Re: Albuquerque School of Excellence
13201 Lomas Blvd NE Albuquerque NM 87112
Traffic Circulation Layout
Engineer's/Architect's Stamp 11-07-2018 (J22D050)

Based upon the information provided in your submittal received 11-08-2019, the above referenced plan cannot be approved for Building Permit until the following comments are addressed:

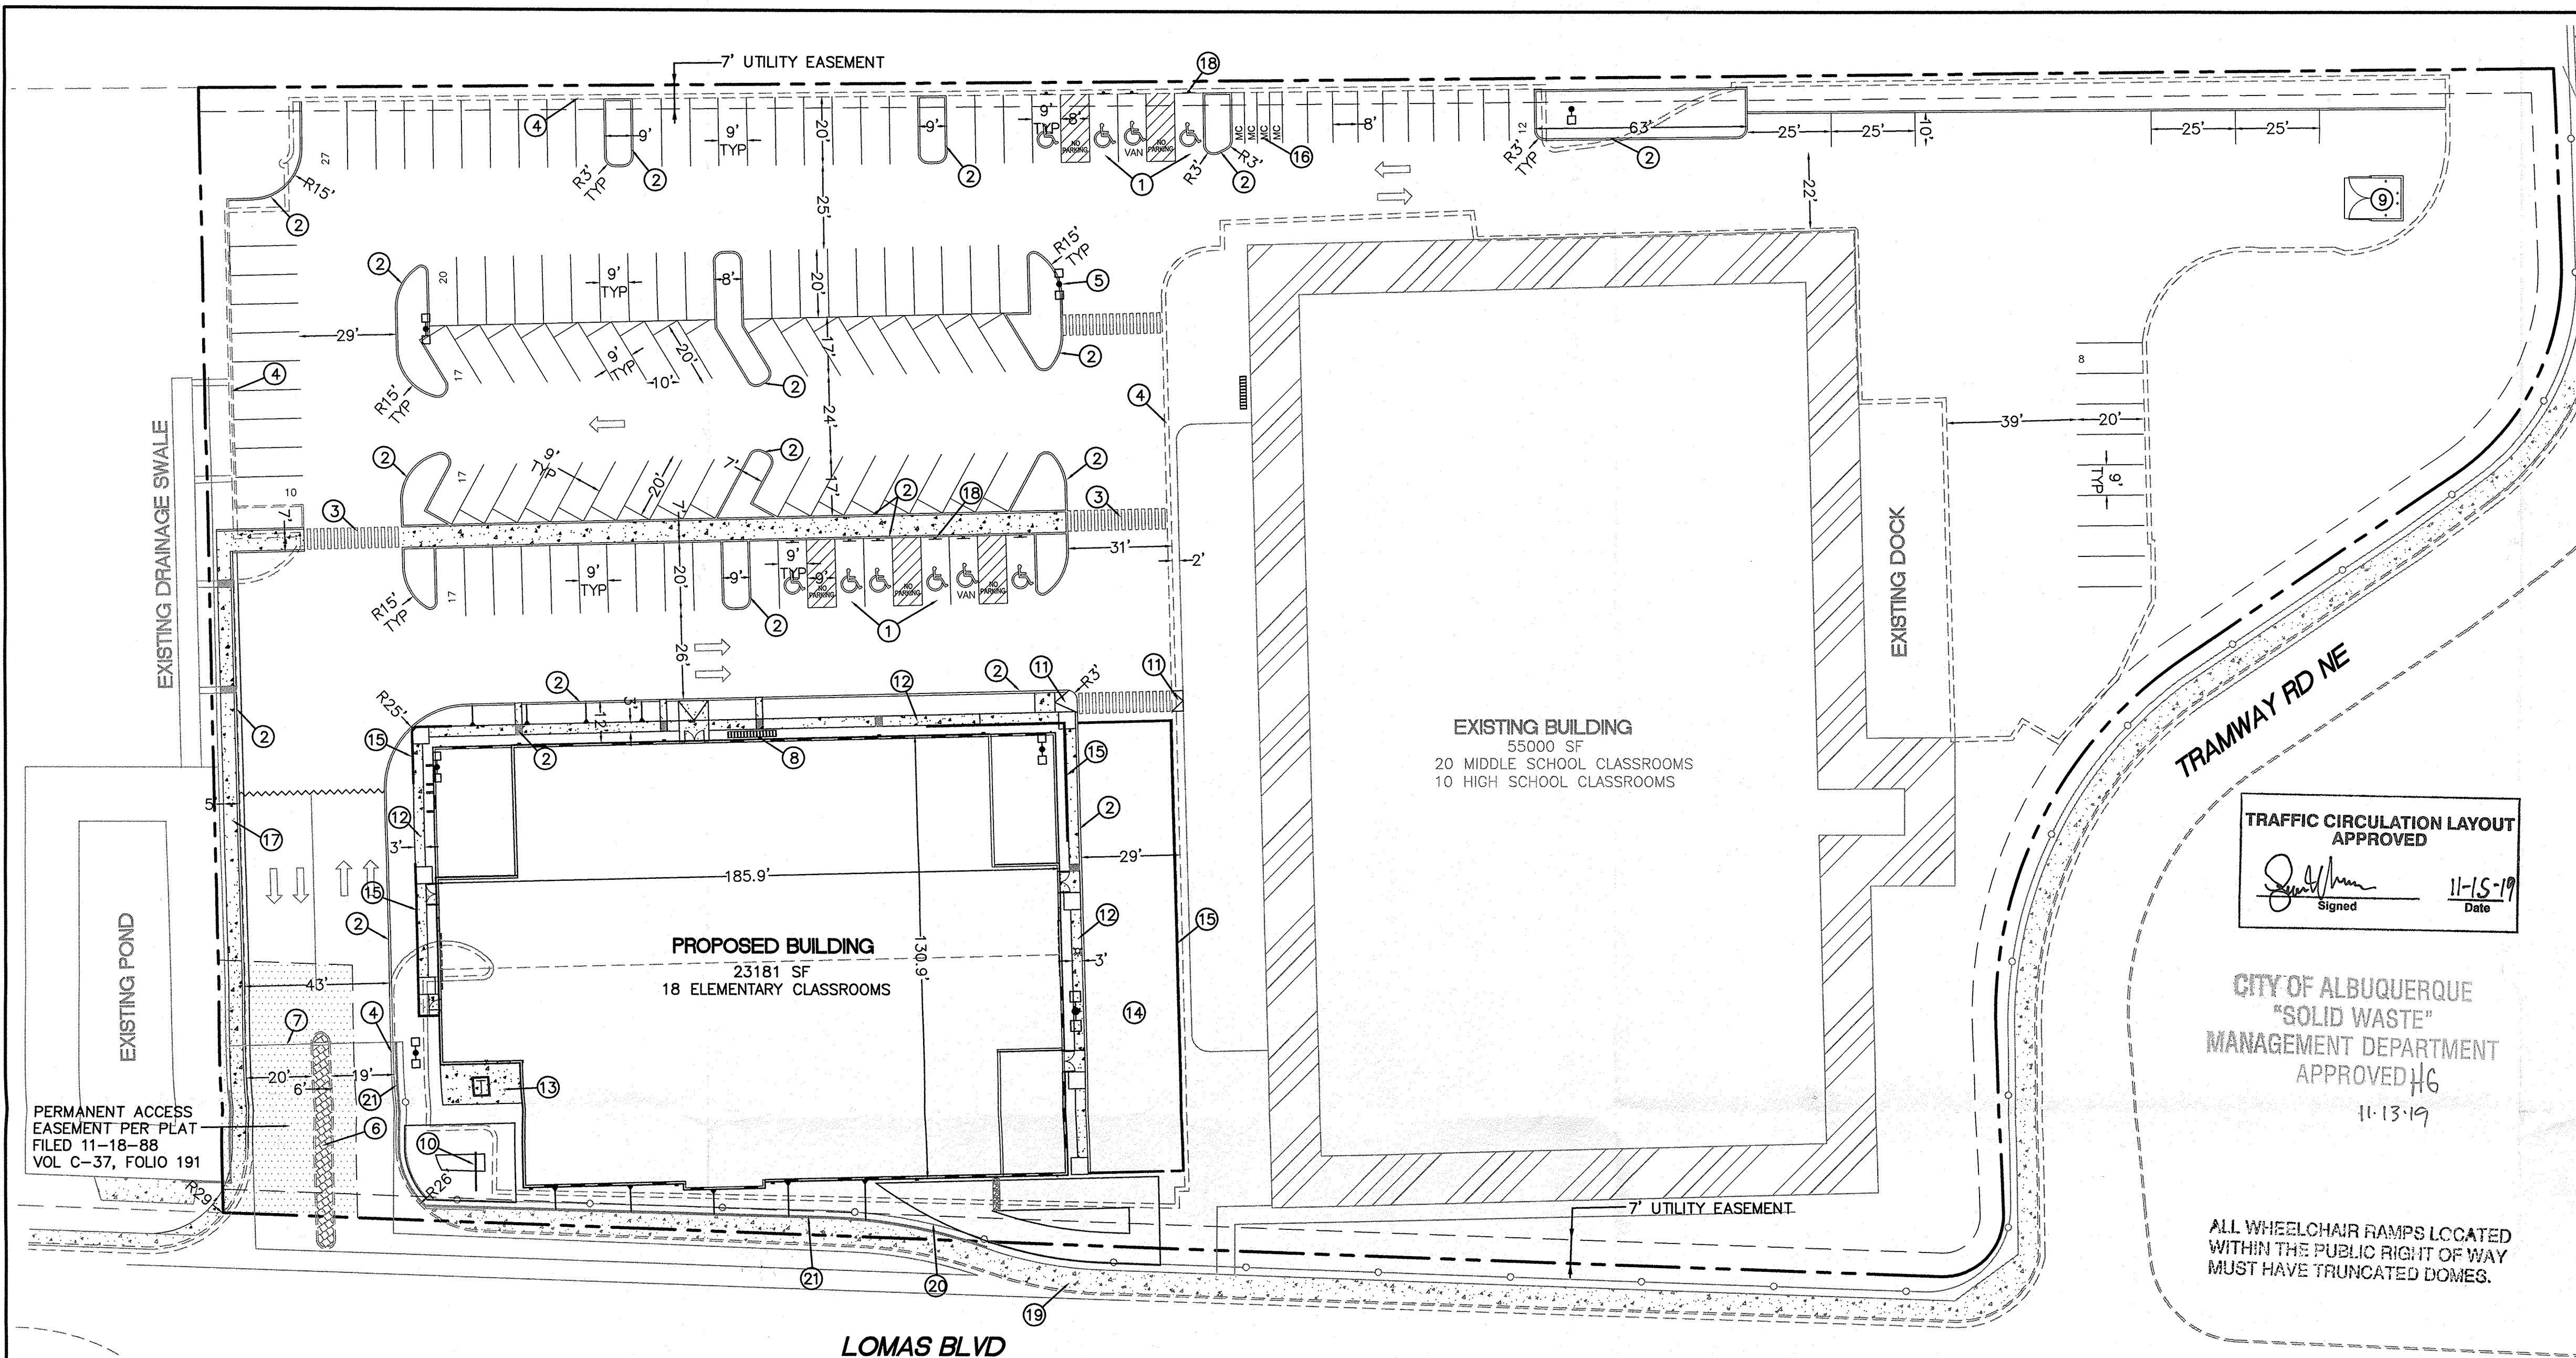
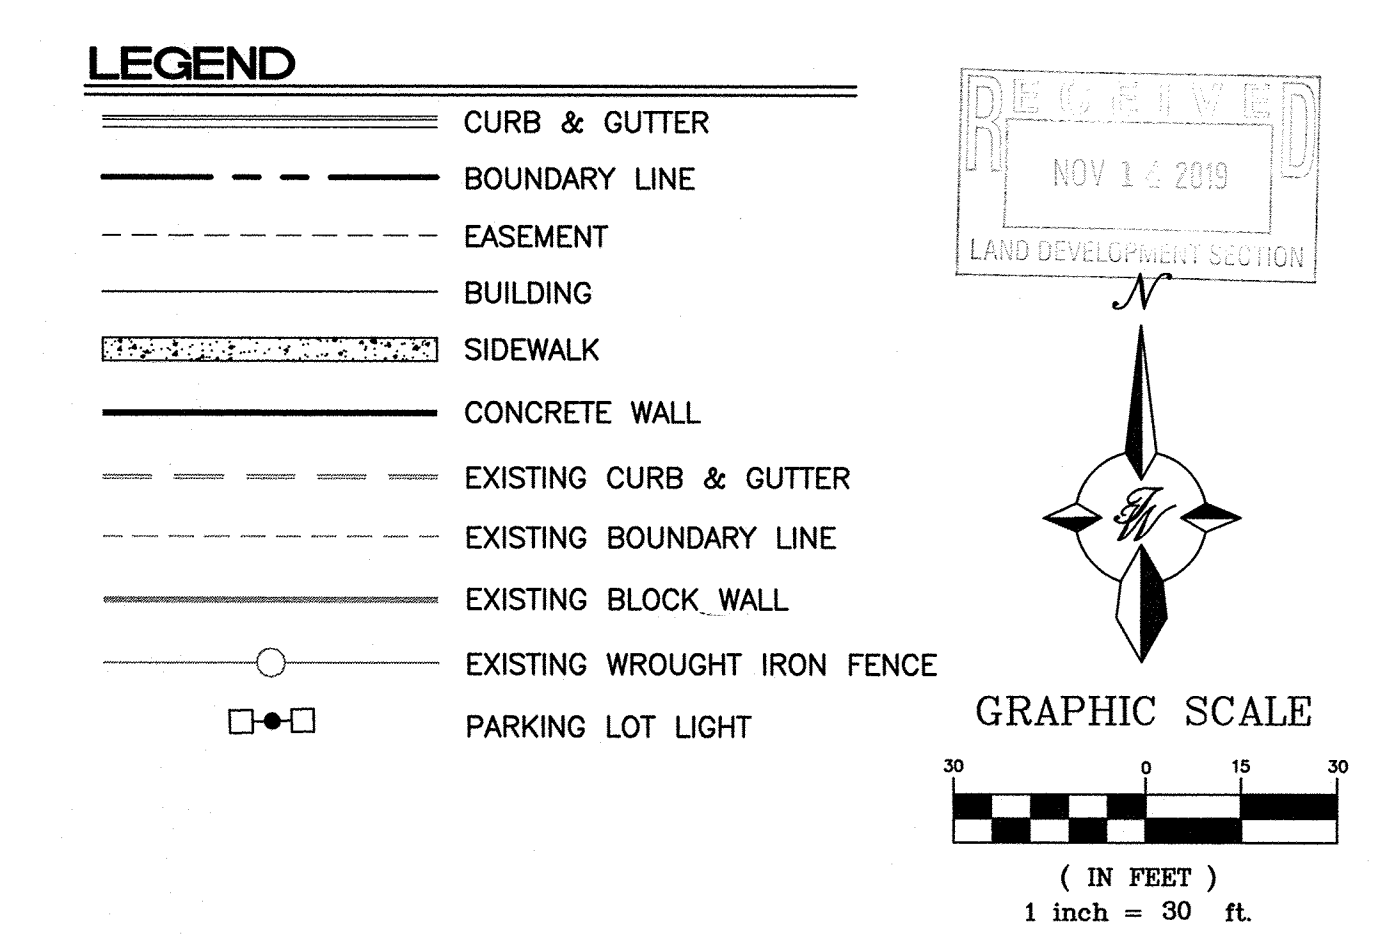
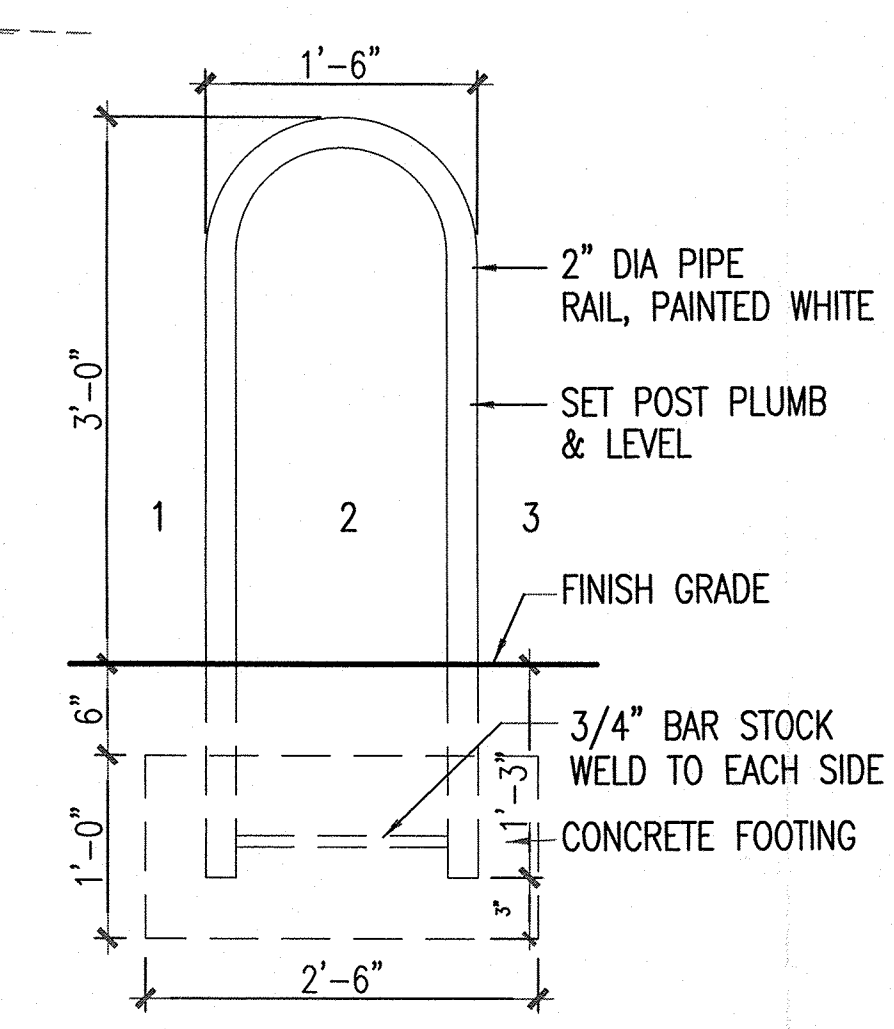
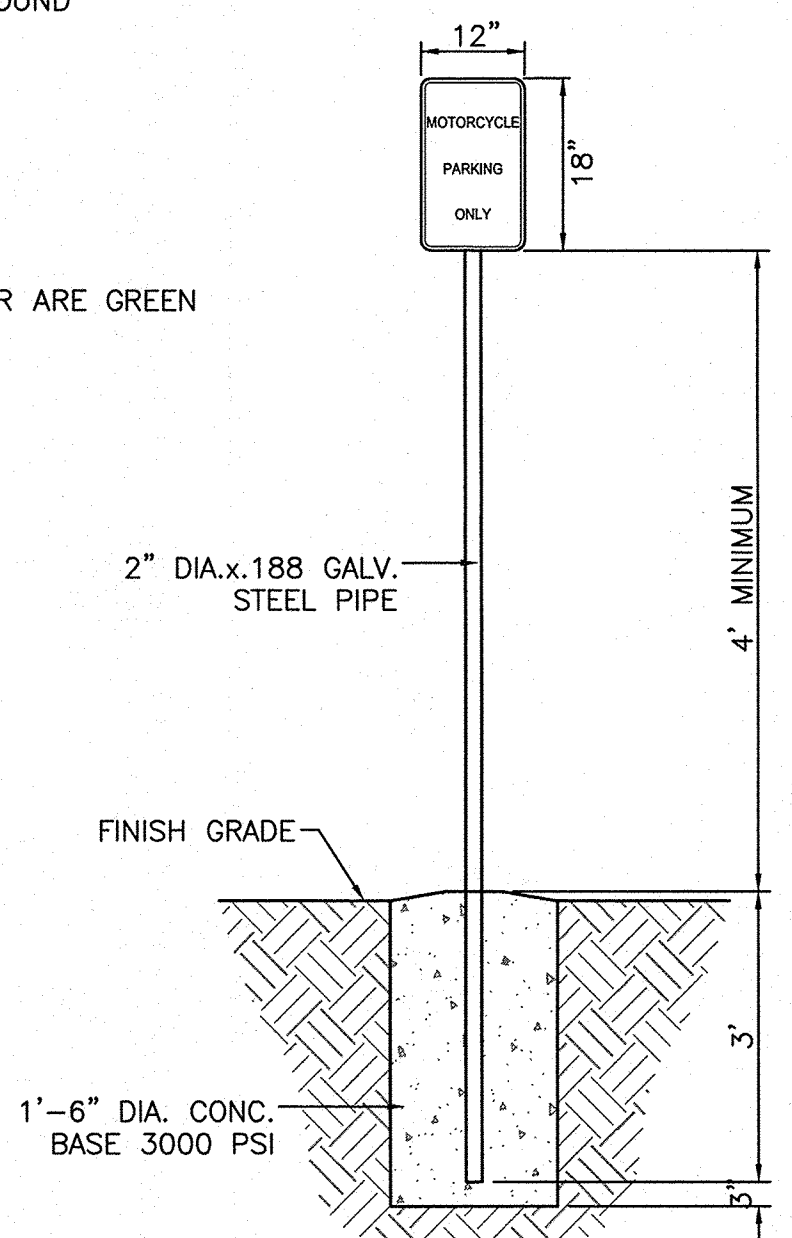
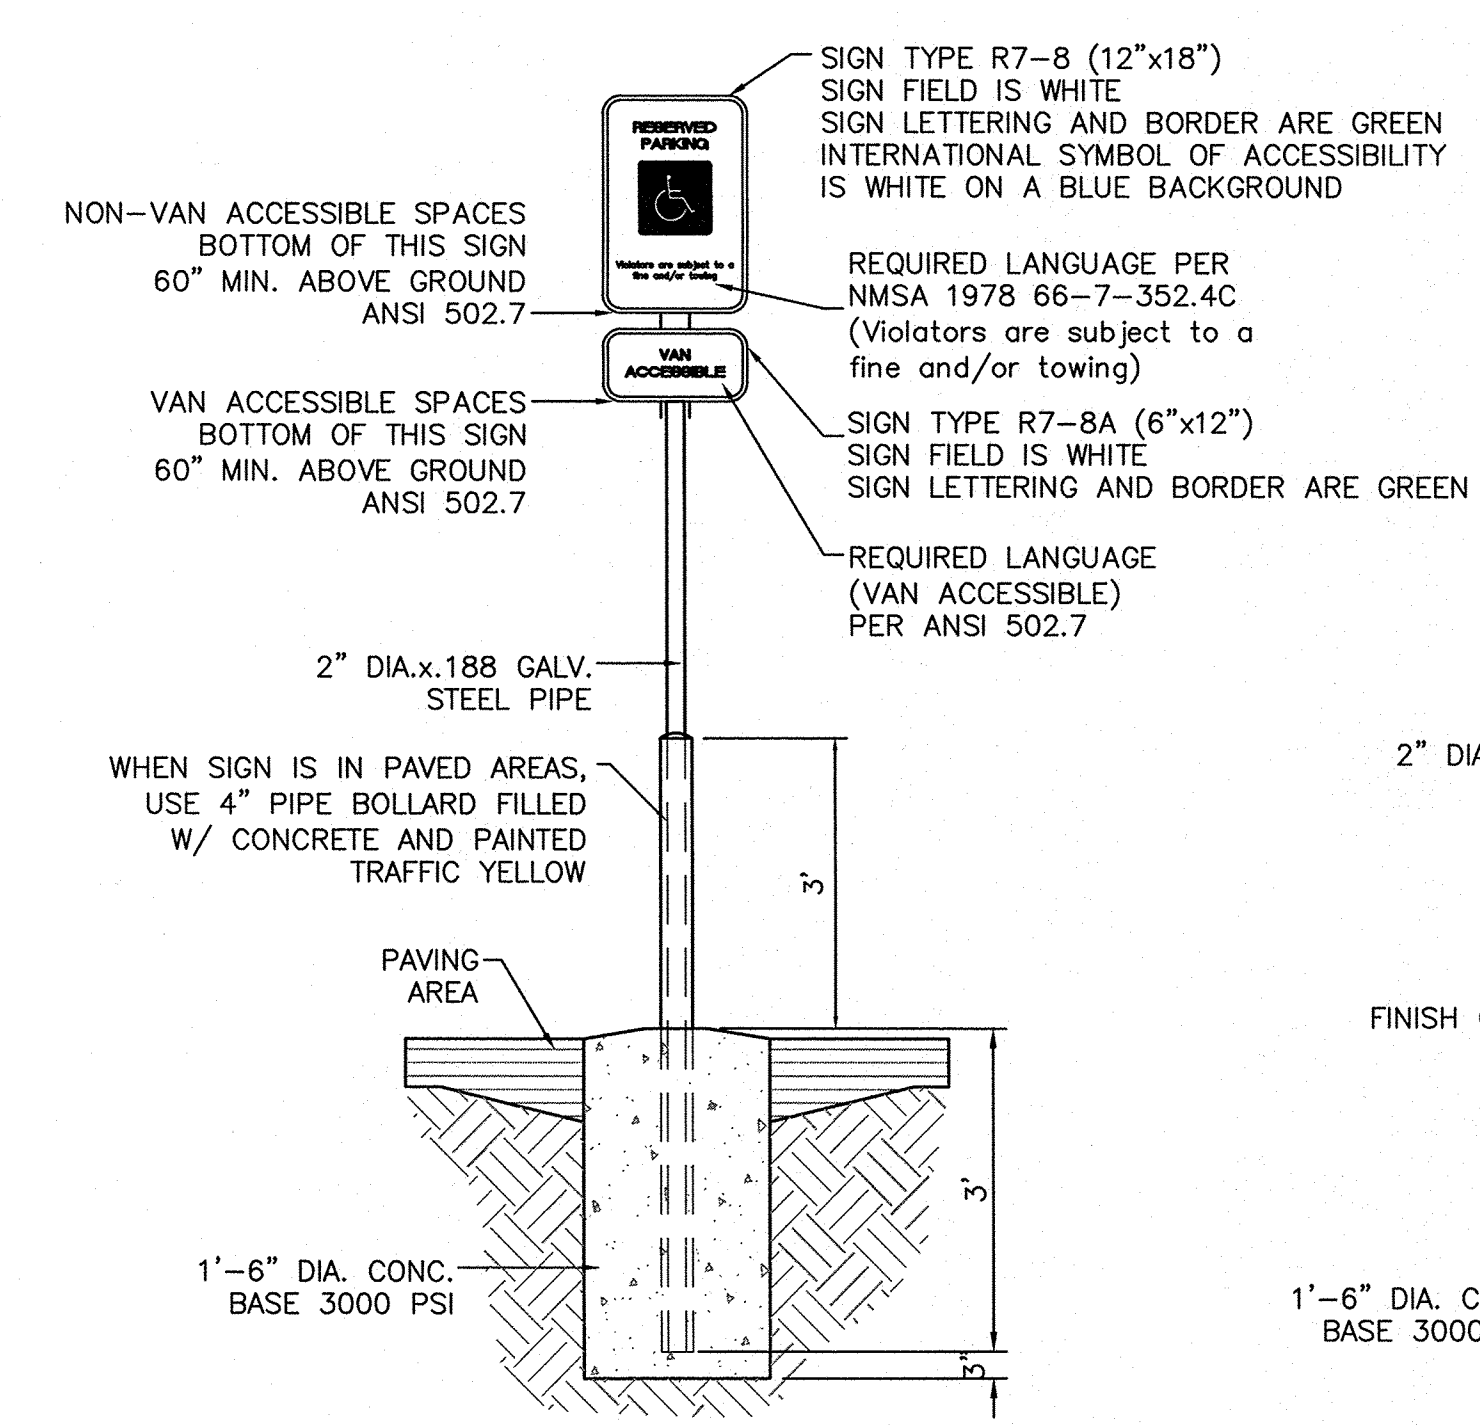
1. The ADA accessible parking sign must have the required language per 66-7-352.4C NMSA 1978 **"Violators Are Subject to a Fine and/or Towing."** Please call out detail and location of signs.

2. The ADA access aisles shall have the words **"NO PARKING"** in capital letters, each of which shall be at least one foot high and at least two inches wide, placed at the rear of the parking space so as to be close to where an adjacent vehicle's rear tire would be placed. (66-1-4.1.B NMSA 1978)

3. Motorcycle parking spaces shall be designated by its own conspicuously posted upright sign, either free-standing or wall mounted per the zoning code.

4. All bicycle racks shall be designed according to the following guidelines:
 - a. The rack shall be a minimum 30 inches tall and 18 inches wide.
 - b. The bicycle frame shall be supported horizontally at two or more places. Comb/toaster racks are not allowed.

- c. The rack shall be designed to support the bicycle in an upright position. See the IDO for additional information.
 - d. The rack allows varying bicycle frame sizes and styles to be attached.

- e. The user is not required to lift the bicycle onto the bicycle rack.
 - f. Each bicycle parking space is accessible without moving another bicycle.

5. Bicycle racks shall be sturdy and anchored to a concrete pad.
6. A 1-foot clear zone around the bicycle parking stall shall be provided.
7. Bicycle parking spaces shall be at least 6 feet long and 2 feet wide.

8. Refuse vehicle maneuvering shall be contained on-site. The refuse vehicle shall not back into the public right of way.; provide a copy of refuse approval.
